Development Facilitation Team (DFT) – Review Comments

Project No: PR-2022-006673 Date: 8/28/2024 Agenda Item: #1 Zone Atlas Page: H-22

Request: Subdivide one existing tract into two new tracts, grant private access easement.

Application For: SD-2024-00123 – PRELIMINARY/FINAL PLAT (DFT)

TRACT 1-A-1 AND TRACT 1-A-2 REPLAT OF TRACT 1-A, IN BLOCK 101, PLAT FOR BRENTWOOD HILLS SUBDIVISION, CITY OF ALBUQUERQUE, BERNALILLO COUNTY, NEW MEXICO

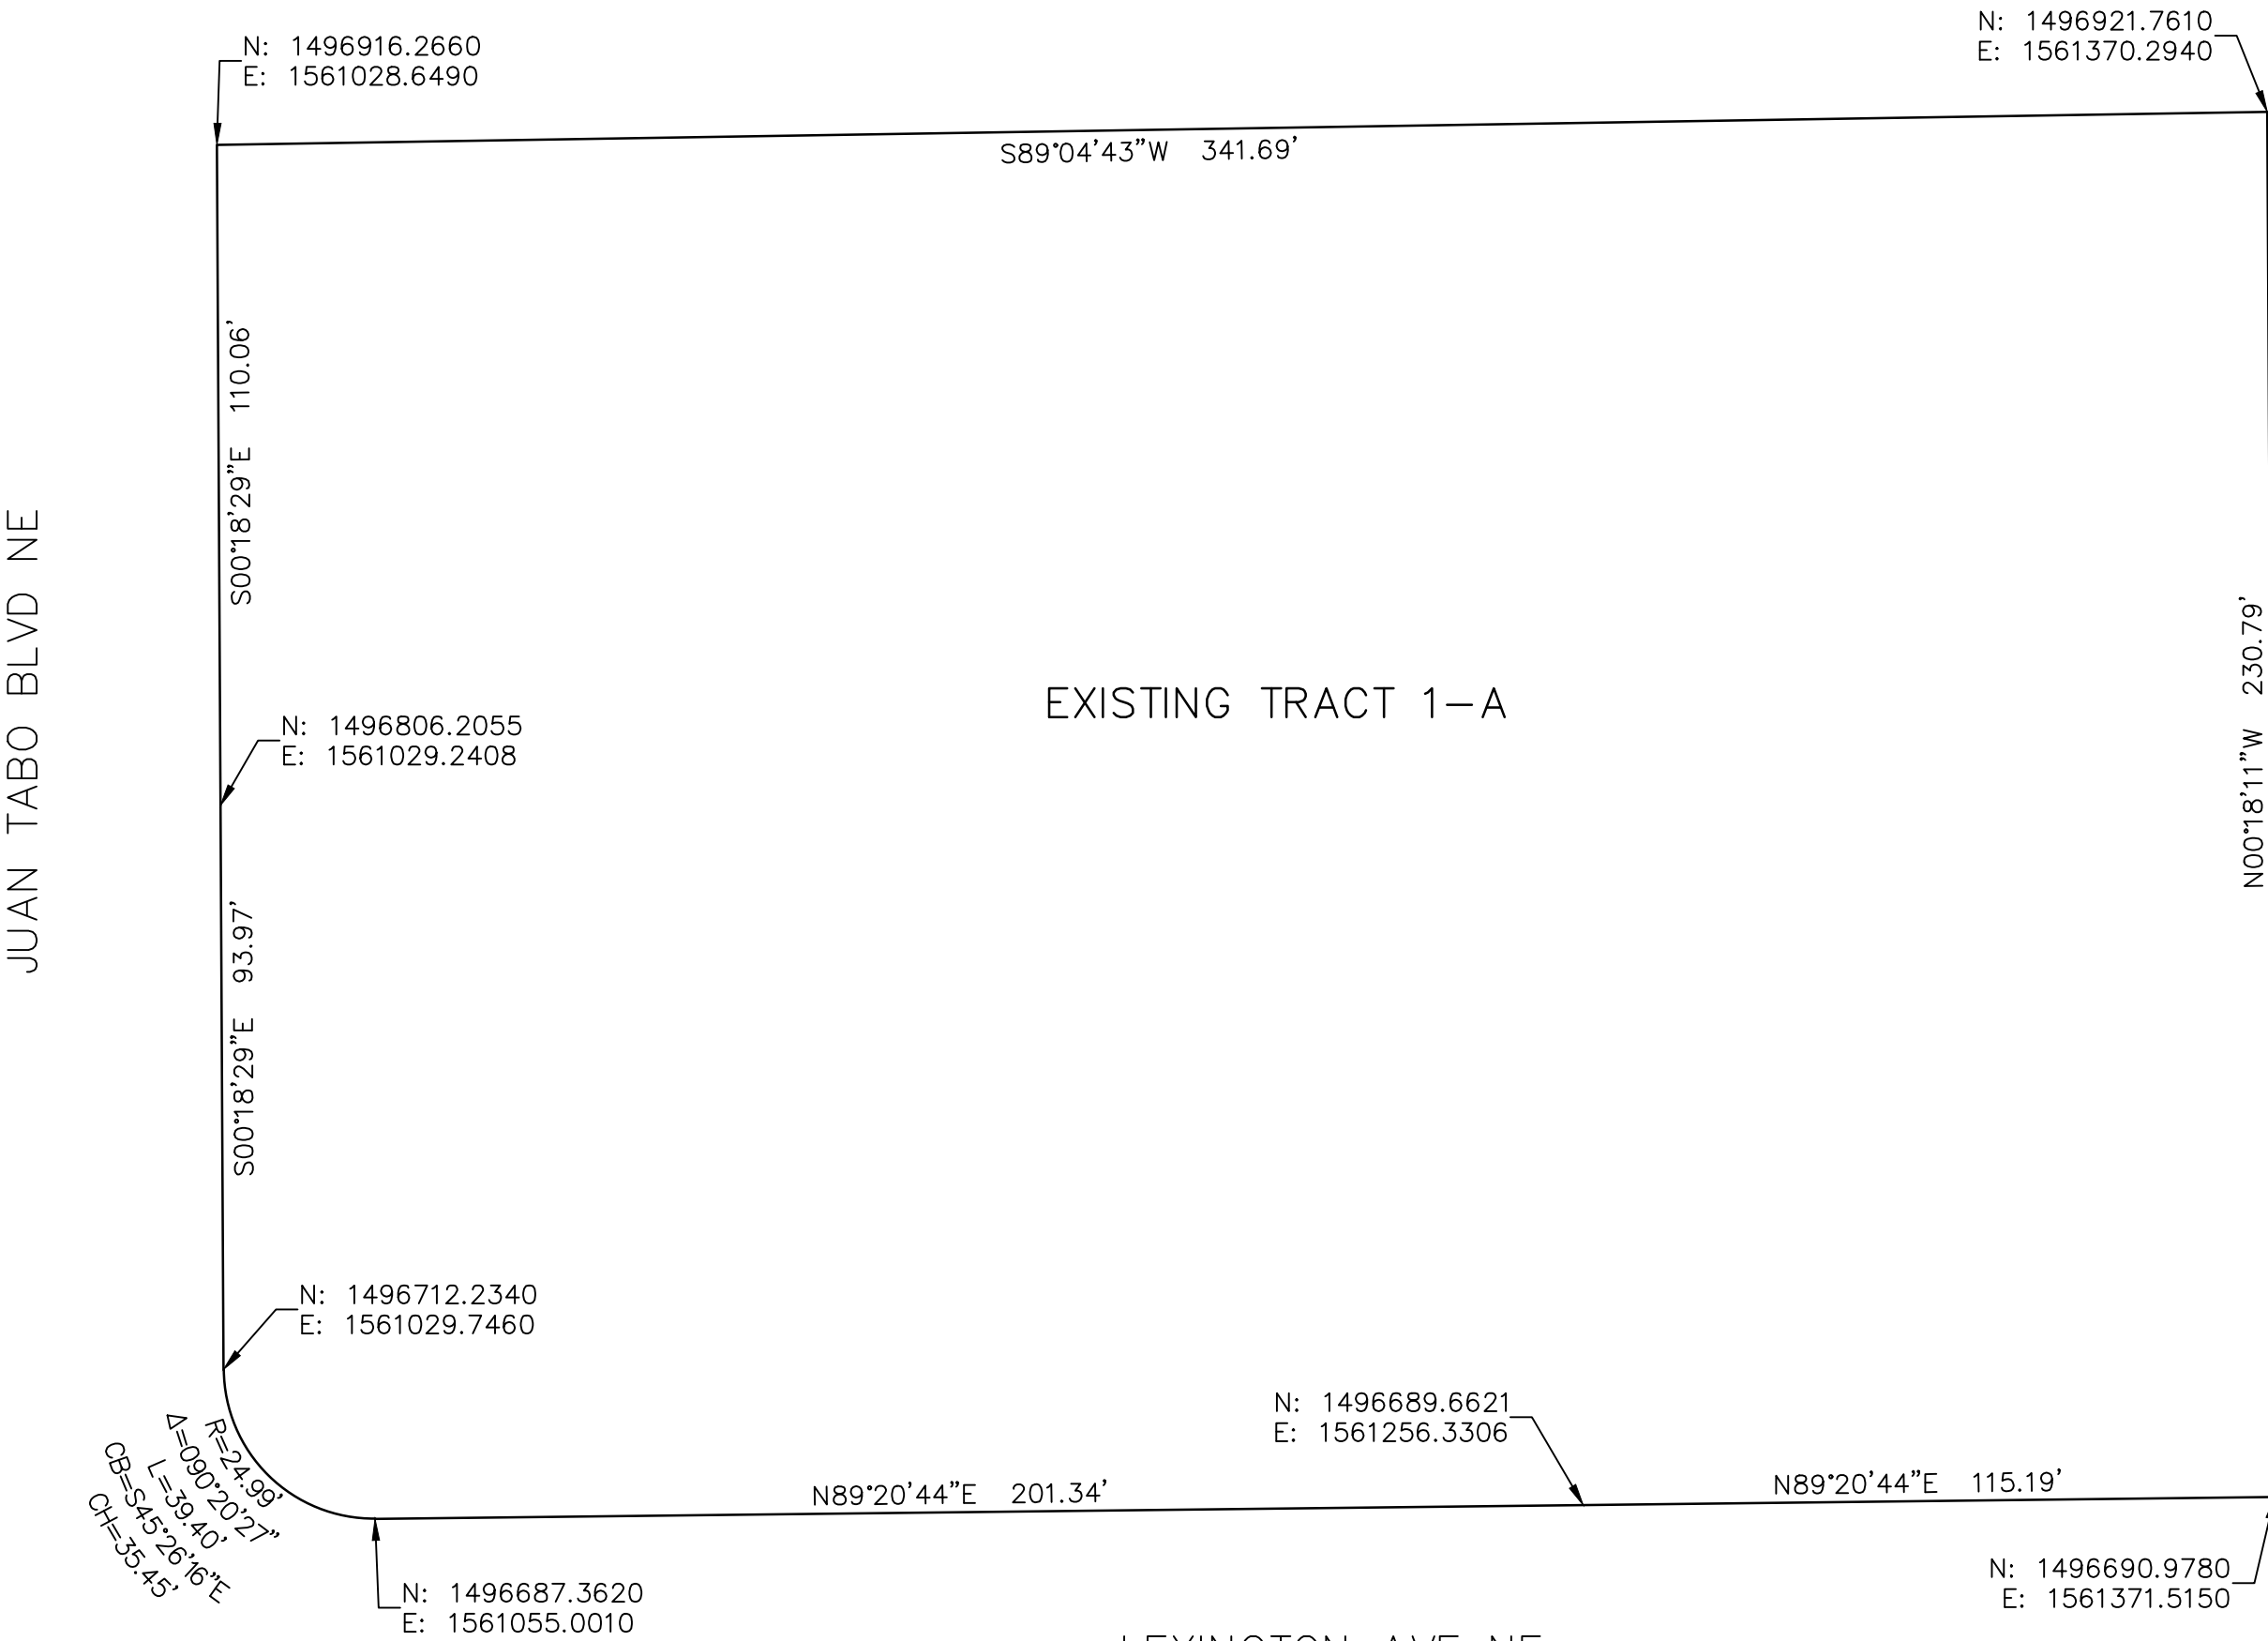
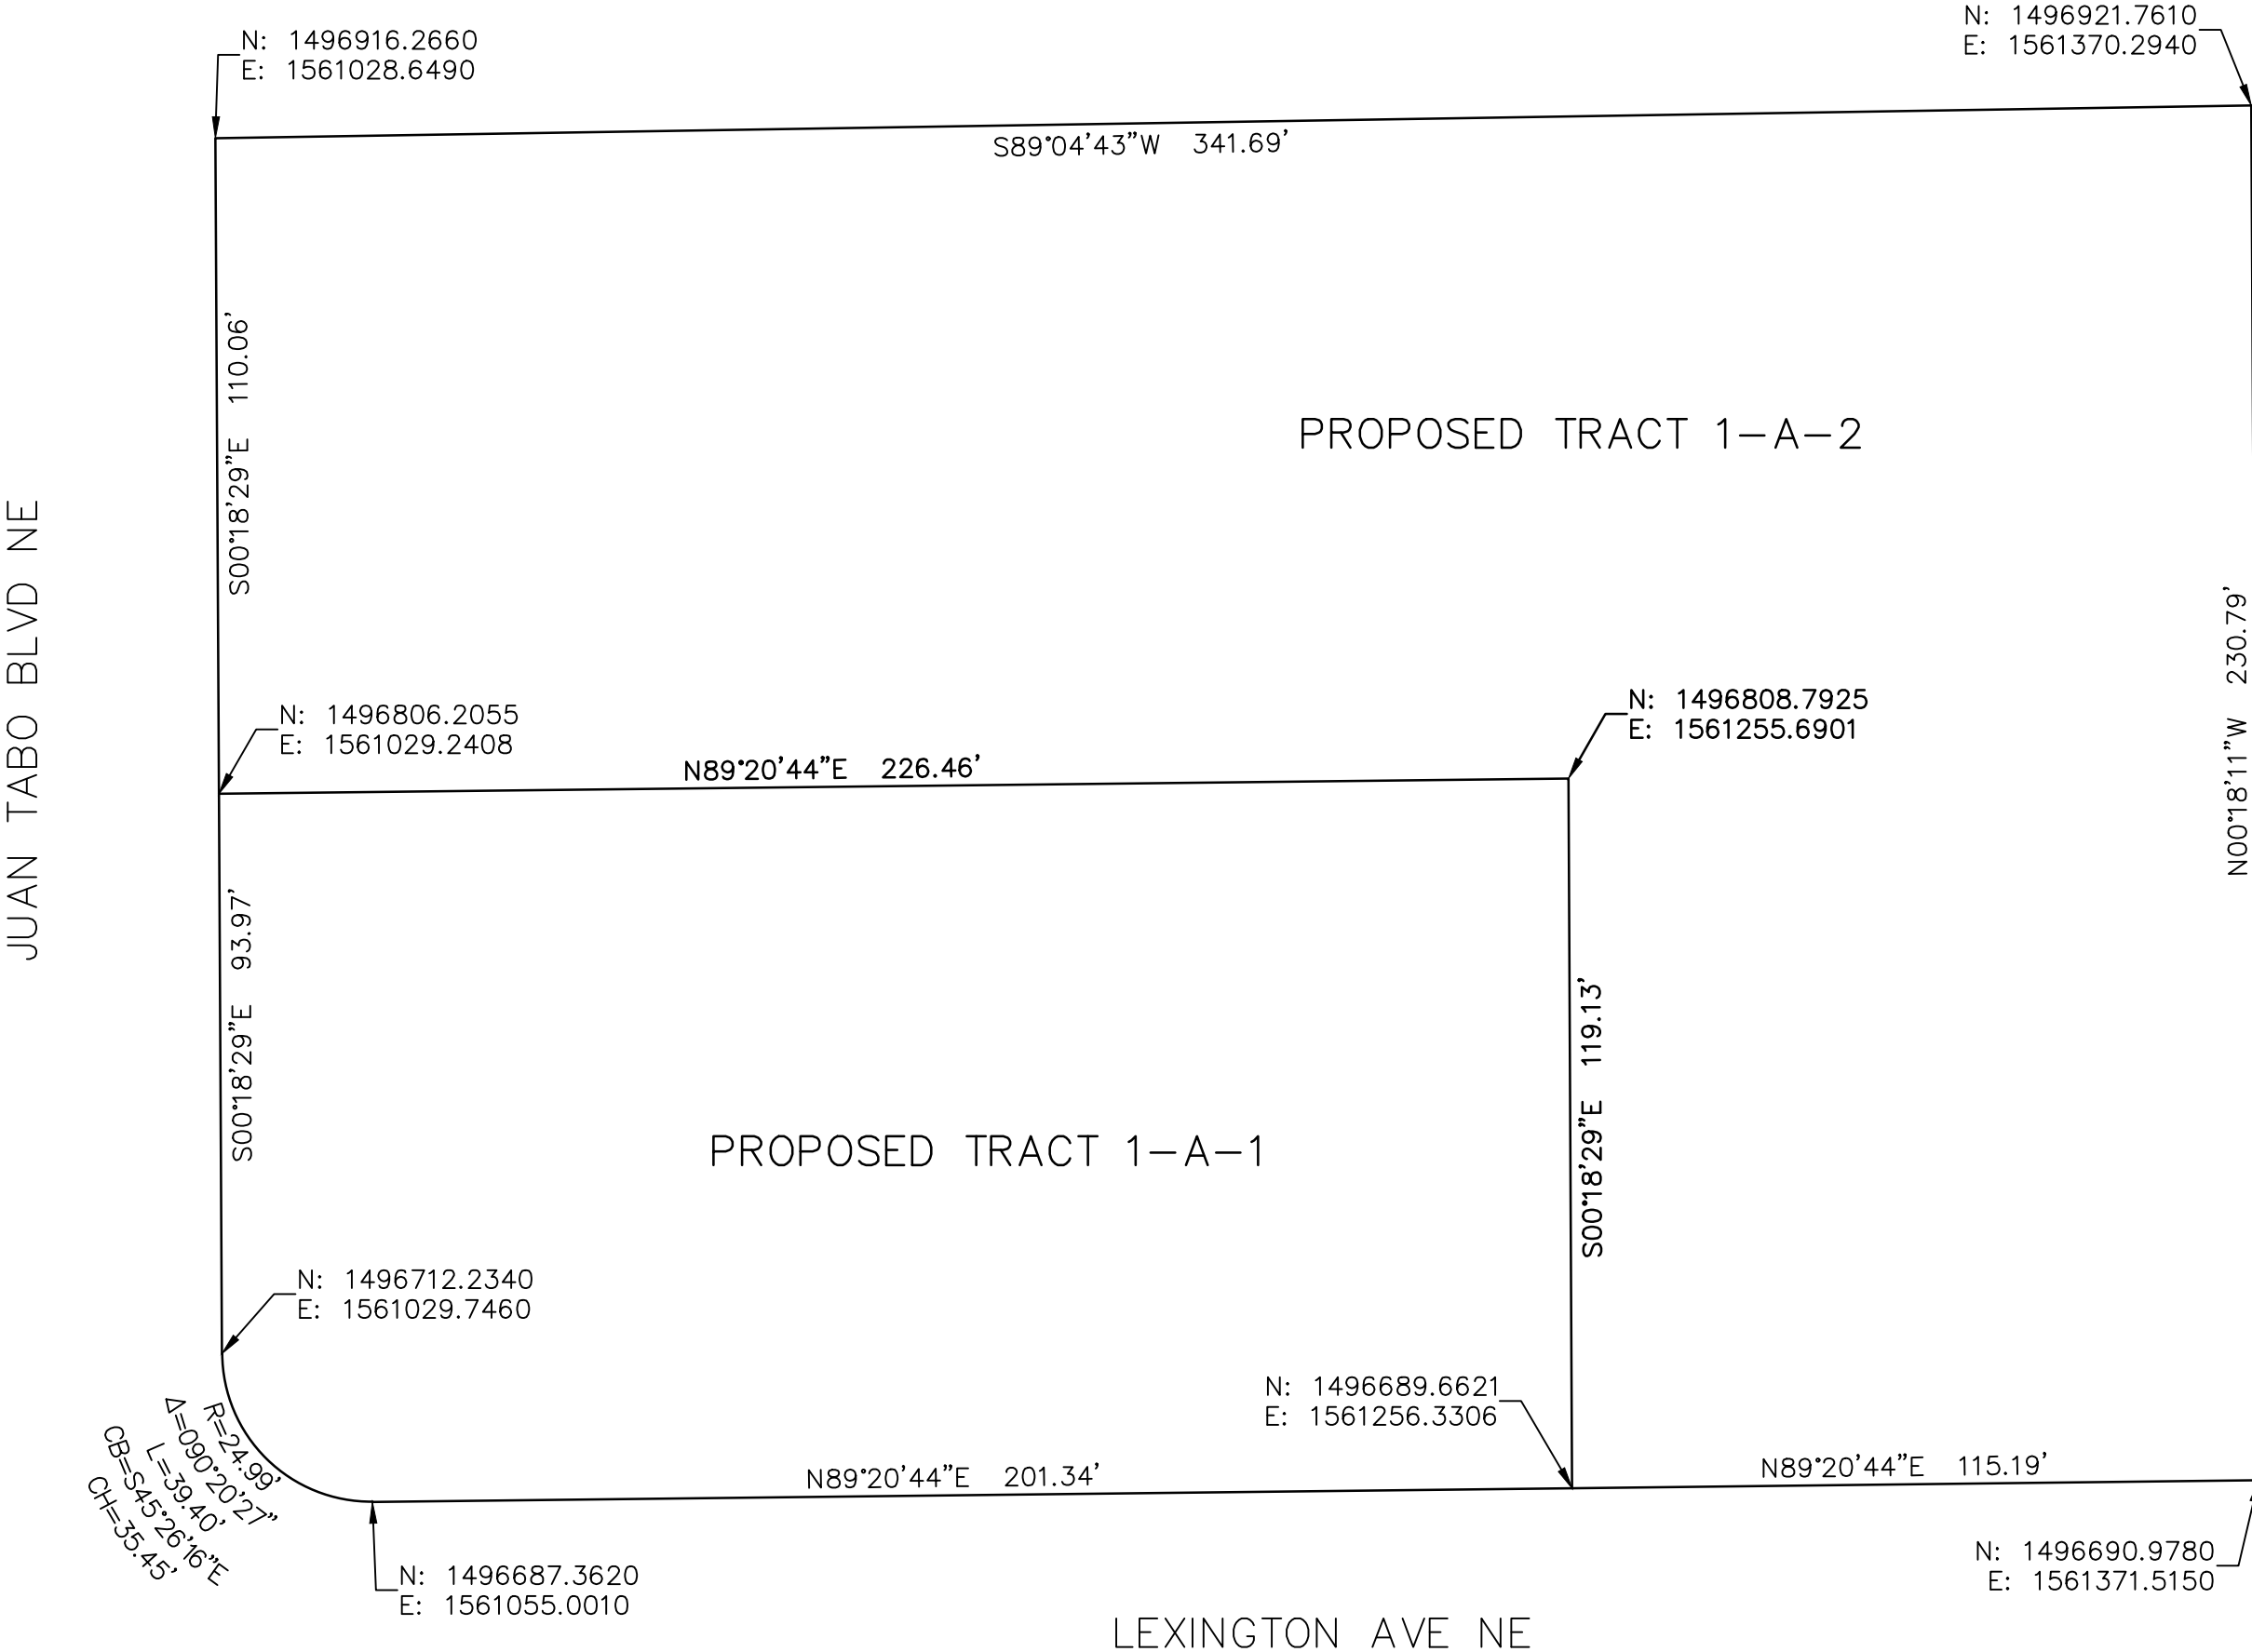
- Hydrology has an approved Grading & Drainage Plan (H22D080) with engineer's stamp 08/17/2023 for **Tracts 1-A-1**.
- **Add a Cross Lot Drainage Easement note specifying the beneficiary and maintenance agreement.**
- Comment – **Tracts 1-A-2** - Prior to submitting for Building Permit, a licensed New Mexico civil engineer will need to submit a Grading & Drainage Plan to Hydrology for review & approval if one of these conditions is met. (500 cy of grading, 1,000 sf of proposed building, or 10,000 sf of proposed paving).

- Please confirm the details of the proposed Preliminary/Final plat for the DHO.
*Subdivision of land, one existing lot into two.

- Clarify the details of existing development, demolition, and easements.
- Demonstrate compliance with *Section 7 of the DPM Table 7.2.29, Mesa Del Sol streetscape plan, and the Required Improvements section from 5-4(N) of the IDO.* *Regarding Sidewalk width requirements and the landscape buffer.

- The Project and Application numbers must be added to the plat before final sign-off.
- A copy of the AGIS-approved DXF file must be submitted prior to the final sign-off of the Plat.
